## Active Travel England Planning Application Assessment Tool - Appraiser Report

<b>Site address</b>	OS Parcel 4347 East Of Pipal Cottage, Oxford Road, Kidlington
<b>Local authority reference</b>	23/01233/OUT
<b>ATE Scheme reference</b>	ATE/23/00144/OUT
<b>Local Planning Authority</b>	Cherwell
<b>Local Highway Authority</b>	Oxfordshire County Council
<b>Completed by - name</b>	Kevin O'Hanlon
<b>Date (DD/MM/YY)</b>	11 July 2023
<b>Application stage</b>	Application
<b>Application type</b>	Outline
<b>Model version</b>	1.5
<b>Assessment outcome</b>	More info needed
<b>Decision (appraiser)</b>	<b>Are not in a position to make a recommendation</b>

The outline application proposes the construction of up to 800 dwellings and mixed-use development on the land, which is the subject of an allocation under policy PR6a in the adopted Cherwell Local Plan Partial Review. As part of the development, a range of community facilities are proposed, such as a primary school, a community hall and commercial and employment uses. Therefore, the development has the potential for many journeys to be contained on-site.

PROPOSED PR6A ACCESS STRATEGY AND CYCLE SUPER HIGHWAY - INCLUDING LEFT IN LEFT OUT PRIORITY AND PARTIAL CYCLOPS SIGNAL JUNCTION (SOUTHERN EXTENT)

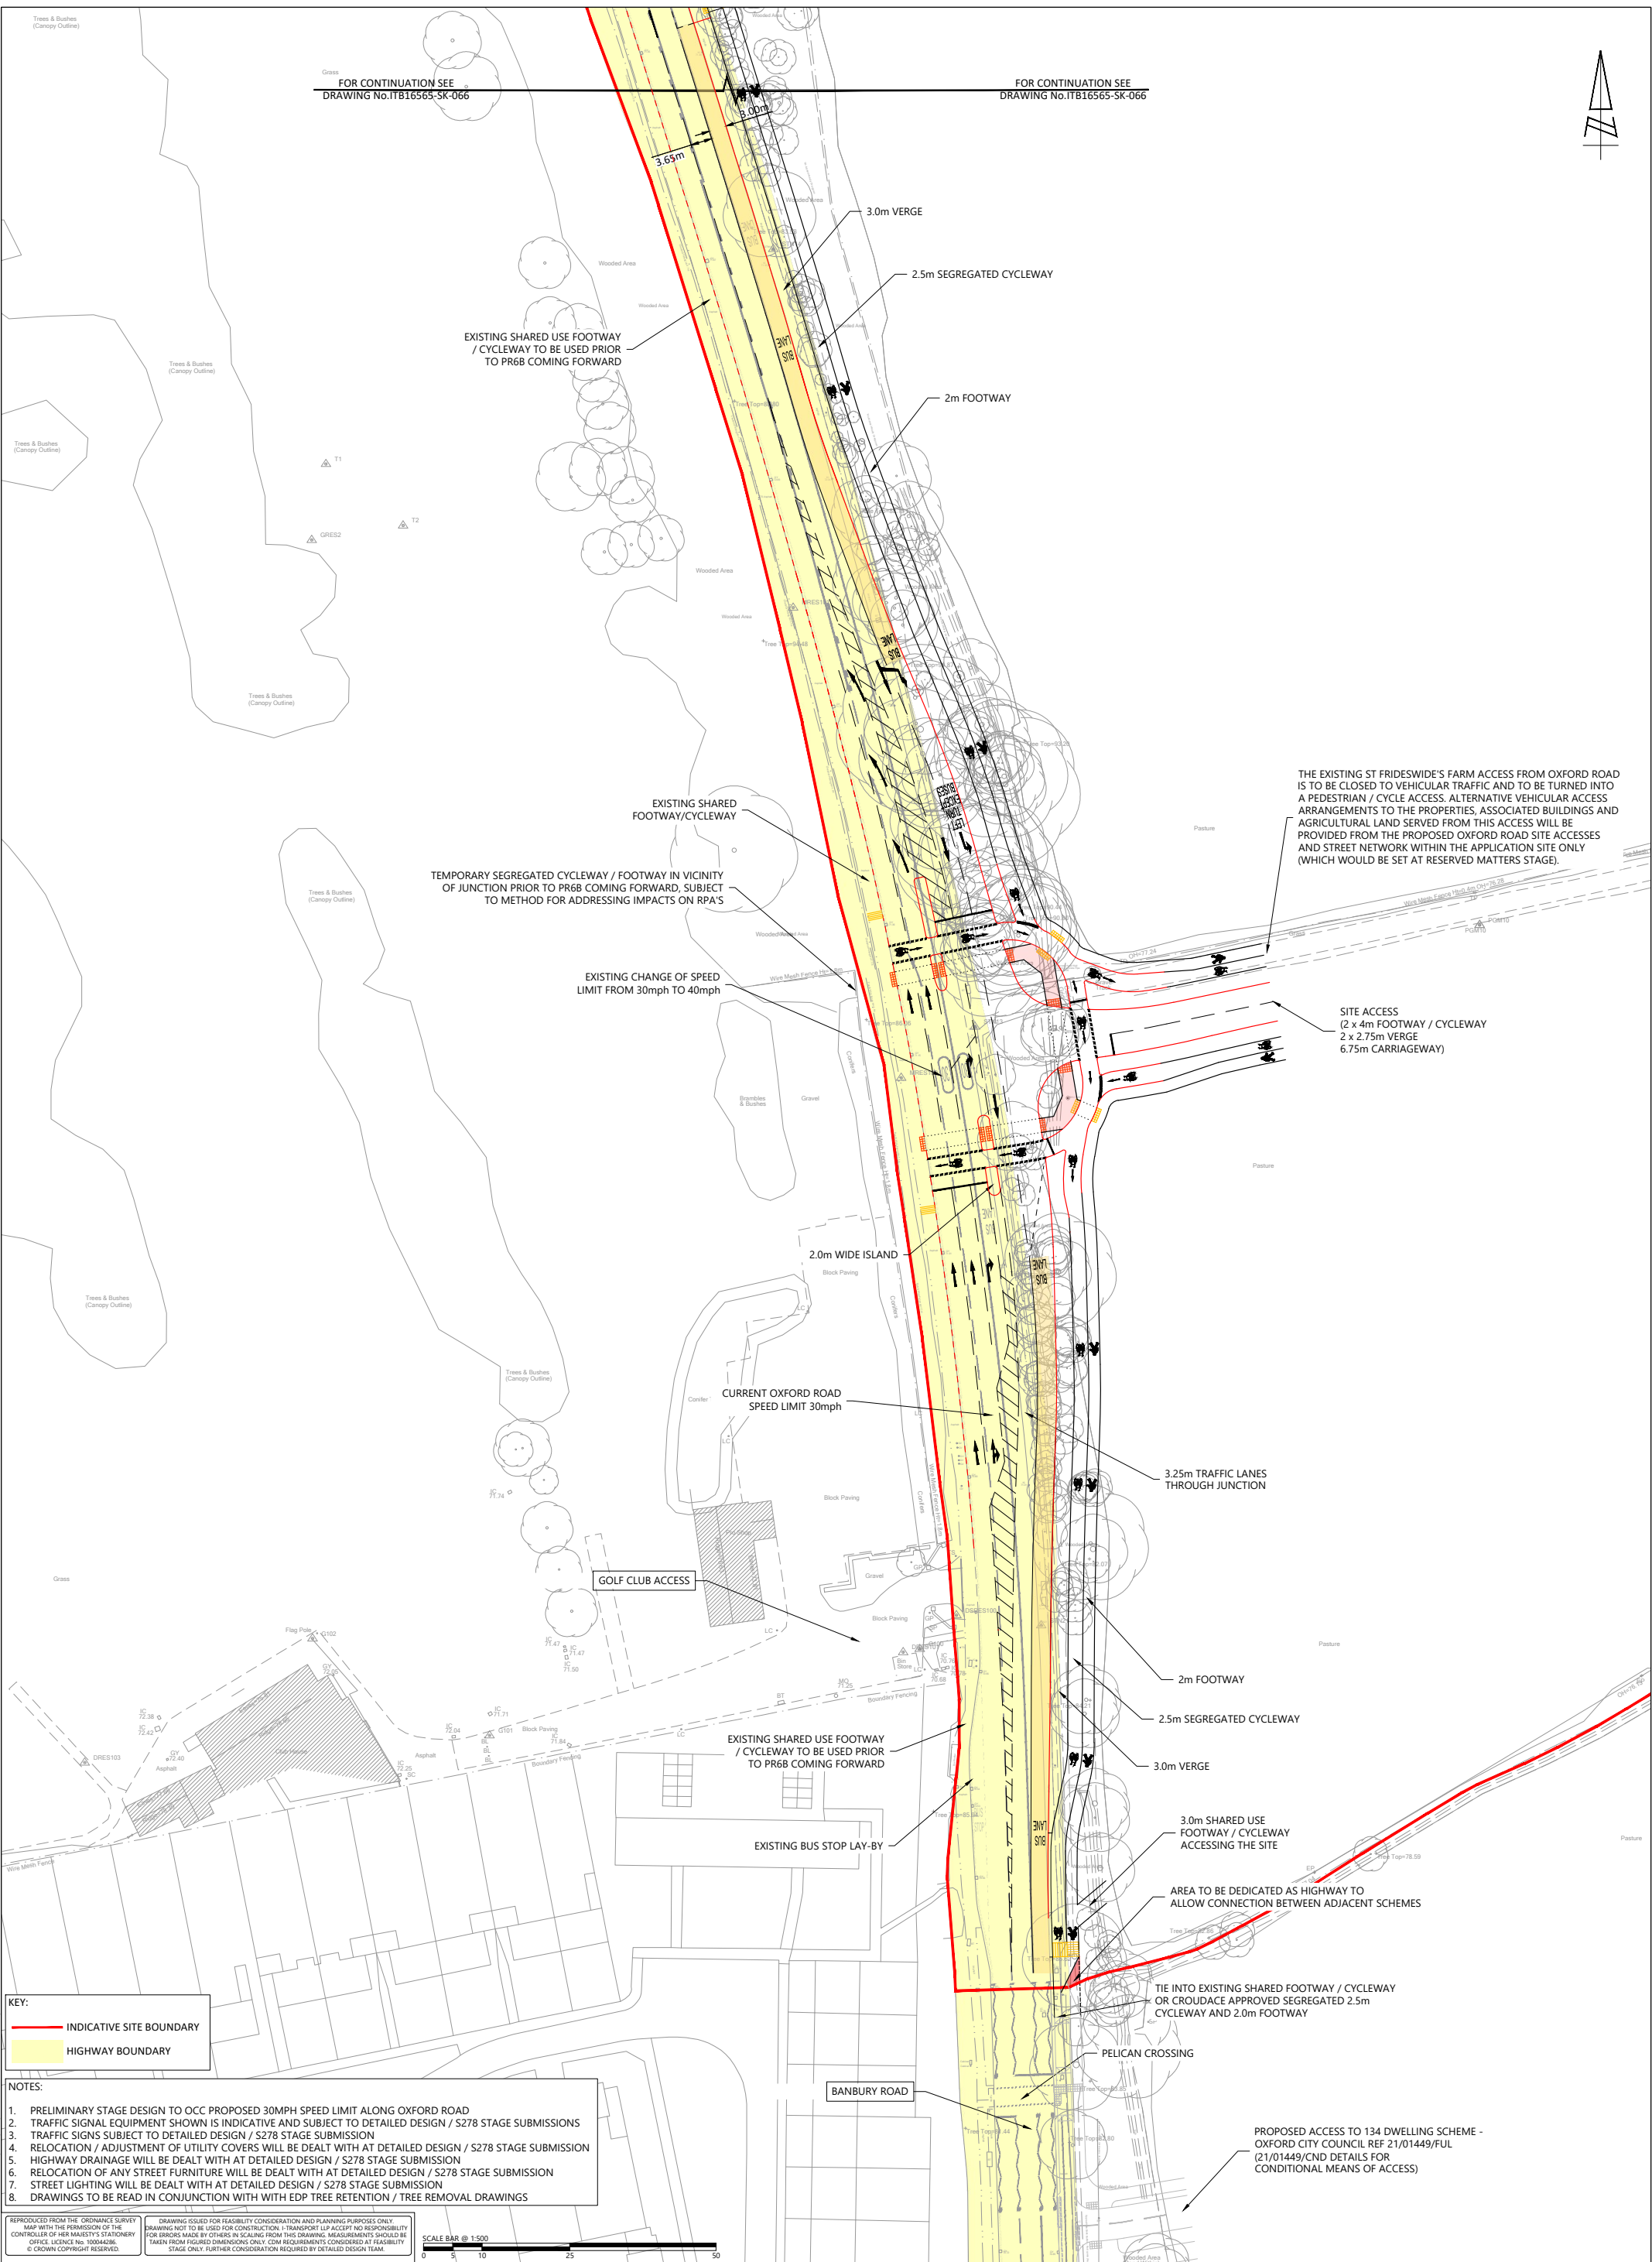
Suitability for walking and wheeling (external to the site)	More info needed	The infrastructure for walking and wheeling external does not comply with Inclusive Mobility guidelines. The current shared footway is well under 2 metres for an extended distance. Confirmation of the proposed improvements and timing would be helpful.		
Safety at junctions (off-site)	PASS	Proposed junctions immediately off-site comply with LTN1 /20		
Cycle routes to key destinations	More info needed	More information is needed on proposed contribution to cycle highway.		
Cycle Safety on links (off-site)	More info needed	current links across the roundabout to major supermarket north of site need improvements.		
Crossings (external to the site)	Recommendation for condition / financial contribution	The current infrastructure at Kidlington Roundabout needs improvements to be compliant with LTN 1/20 and Inclusive Mobility. OXCC's Kidlington roundabout improvement scheme is welcomed and necessary to ensure linkages to nearby facilities are compliant and promotes active travel. A contribution towards this scheme would be appropriate.	NPPF 110c, 112a, 112b; National Model Design Code: 59ii / M.2.ii; LTN 1/20 and other highway guidance; Partial Review Local Plan - PR4a (Sustainable Transport) PR4b (Kidlington Centre). Local Plan (Part 1) SLE4 (Improved Transport and Connections)

Walking and cycling access	More info needed	there are more accessible walking and cycling links. Connections through consented development south of site are not clear.	
Future-proofing and safeguarding	Recommendation for condition / financial contribution	Recommended that highways are adopted by highway authority up to the redline boundary.	NPPF: 88, 92a, 110a, 112c; National Model Design Code: 45 (Figure 11); Partial Review Local Plan - PR4a (Sustainable Transport) PR4b (Kidlington Centre). Local Plan (Part 1) SLE4 (Improved Transport and Connections)
Through traffic	PASS	Through traffic has been designed out.	
Safety at junctions (internal to the site, including site accesses)	PASS	Development is designed as a walkable neighbourhood. TA and DAS note that the majority of streets in the site would be shared streets for pedestrians and cyclists. The widths of the footways and cycleways are needed to ensure compliance with LTN1/20.
